4. **Project# 1009359**  
12DRB-70305 EPC APPROVED SDP  
FOR BUILD PERMIT

ARIA ARCHITECTURE LLC agent(s) for PEAK MOTION PHYSICAL THERAPY request(s) the above action(s) for all or a portion of Lot(s) 20A, Block(s) 10, Tract(s) 2, **NORTH ALBUQUERQUE ACRES Unit(s) 3**, zoned SU-2 MIXED USE, located on HOLLY AVE NE BETWEEN LOUISIANA AND WYOMING containing approximately .5907 acre(s). (C-19) [*Deferred from 10/3/12*]**THE SITE DEVELOPMENT PLAN FOR BUILDING PERMIT WAS APPROVED WITH FINAL SIGN-OFF DELEGATED TO PLANNING FOR THE FILING OF THE PLAT AND FOR APPROVAL OF THE ADMINISTRATIVE AMENDMENT FOR SITE PLAN FOR SUBDIVISION.**

### HYDROLOGY DEVELOPMENT SECTION DEVELOPMENT REVIEW BOARD MEMO

DEVELOPMENT REVIEW BOARD – SPEED MEMO

SITE DEVELOPMENT PLAN FOR SUBDIVISION

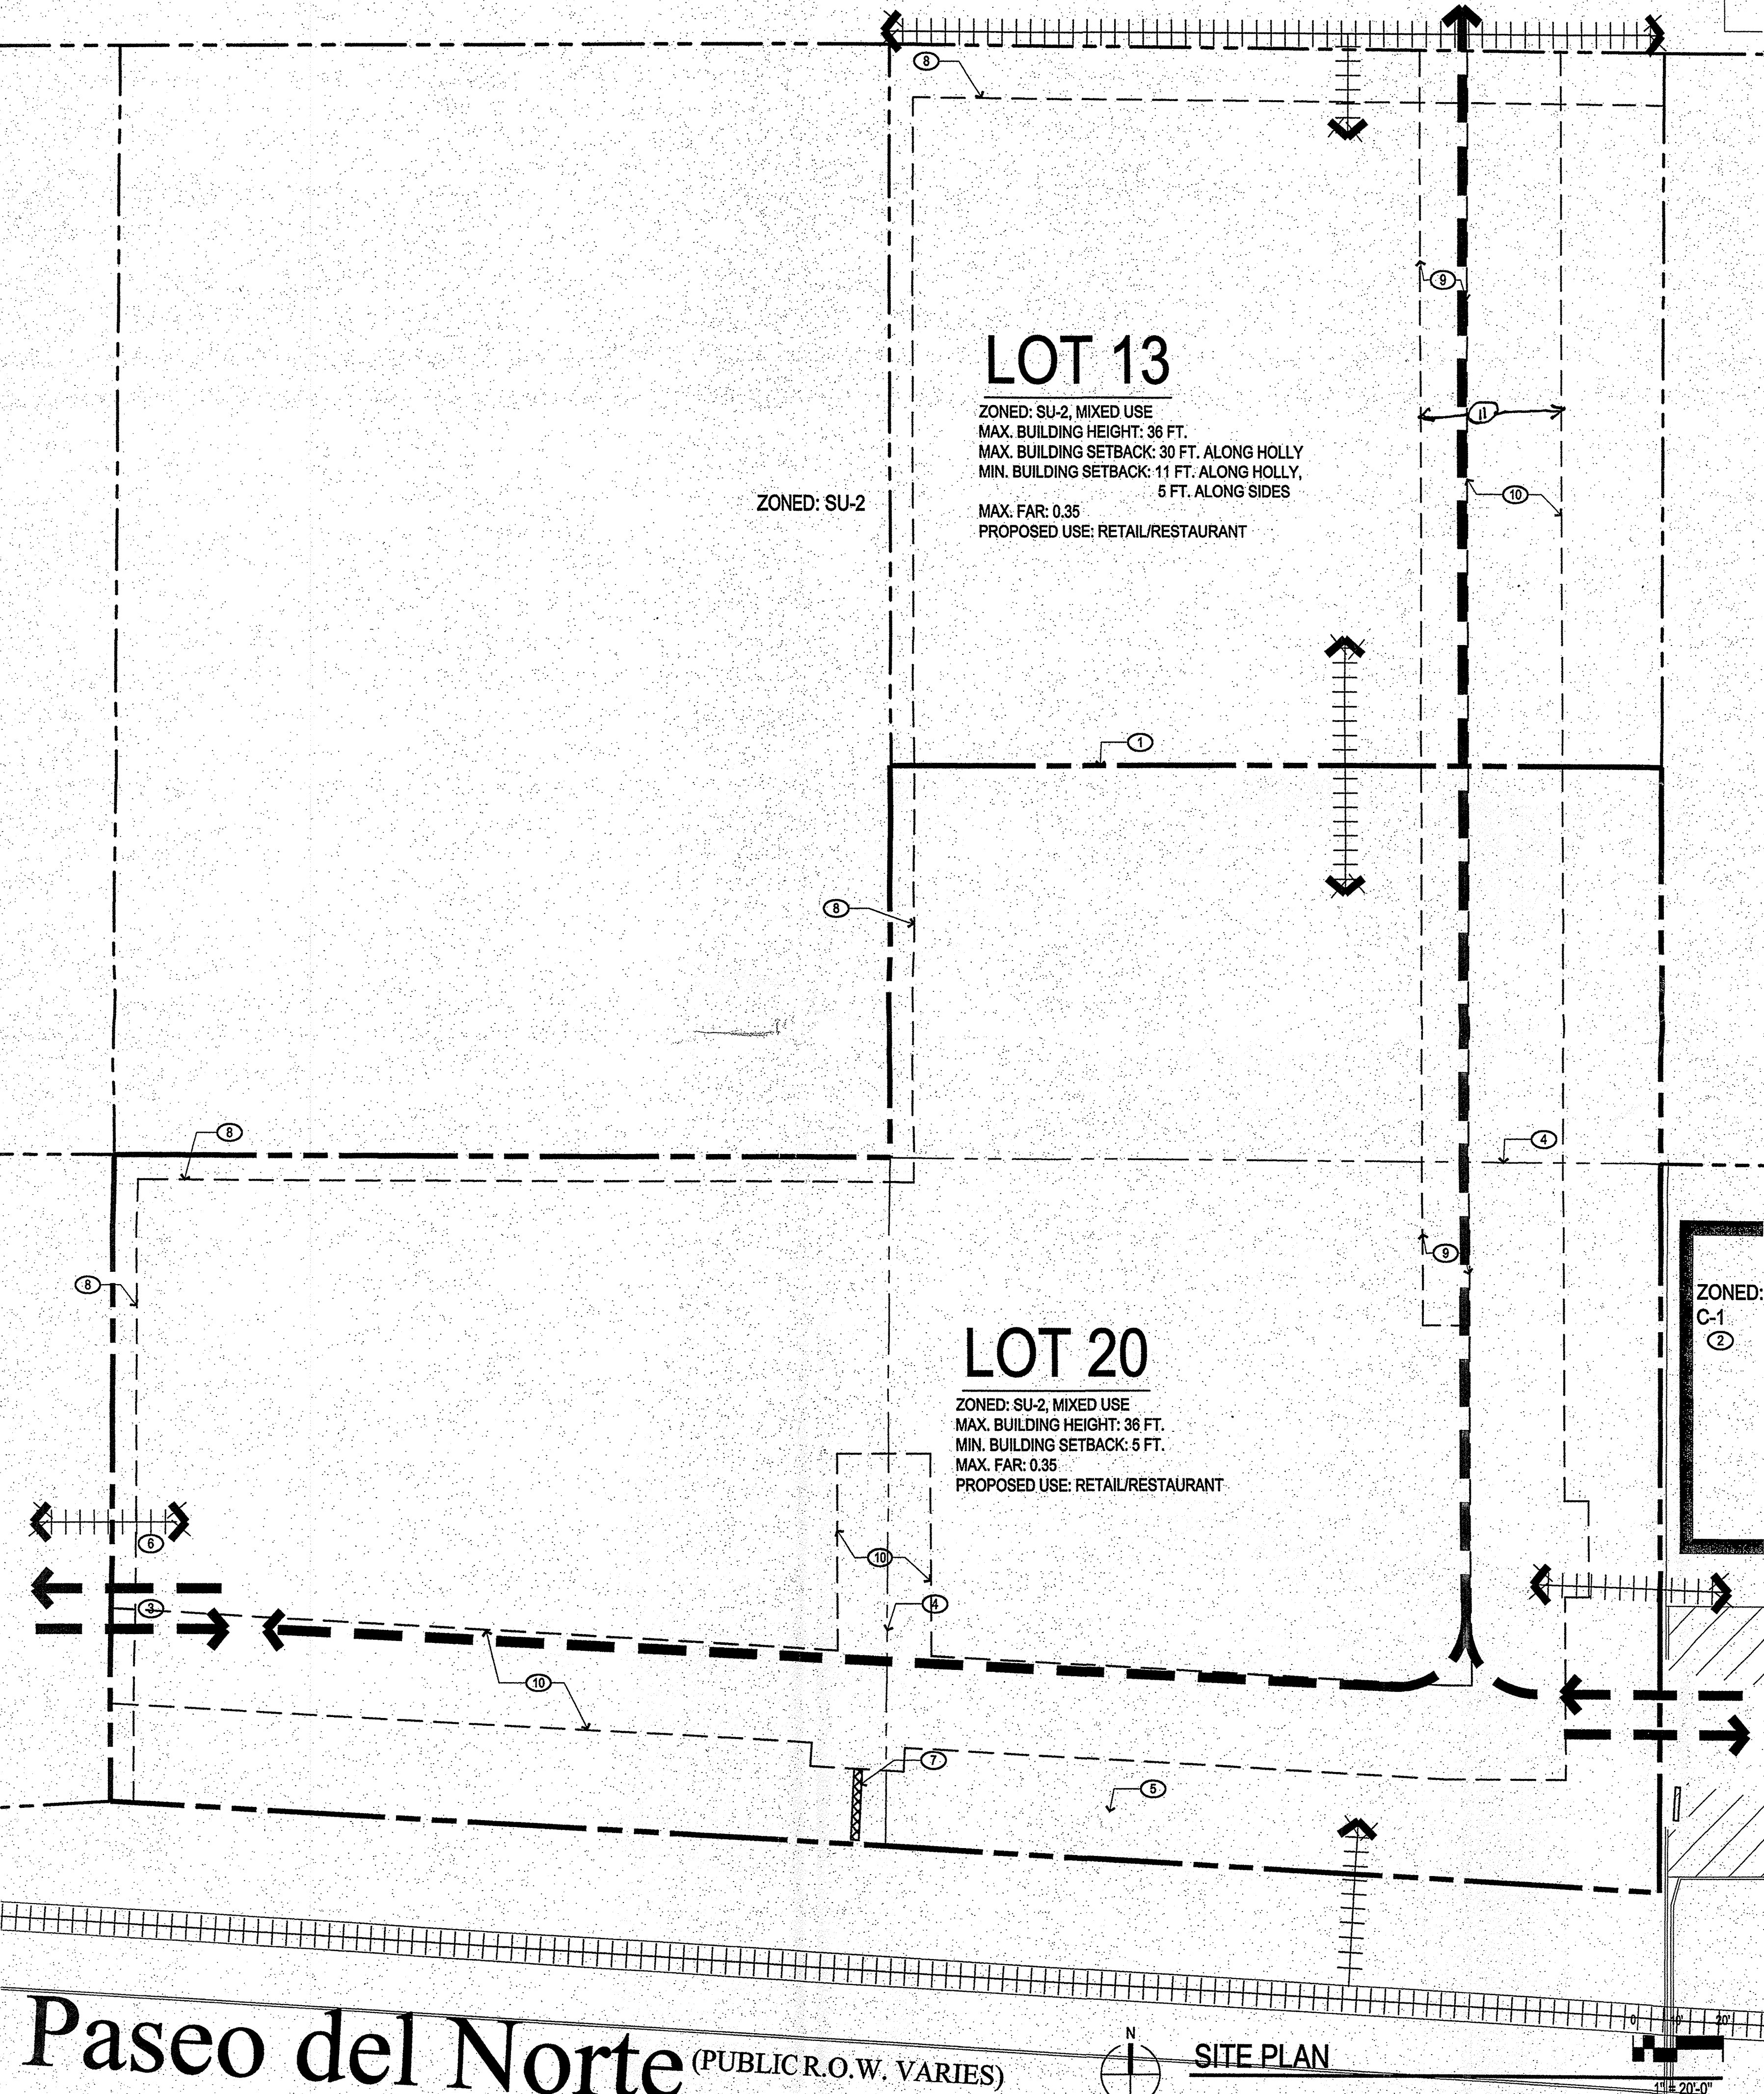
The 2010 Site Plan for Subdivision must be modified (administrative amendment) to reflect the proposed 27-foot wide private access easement (see EPC condition 10).
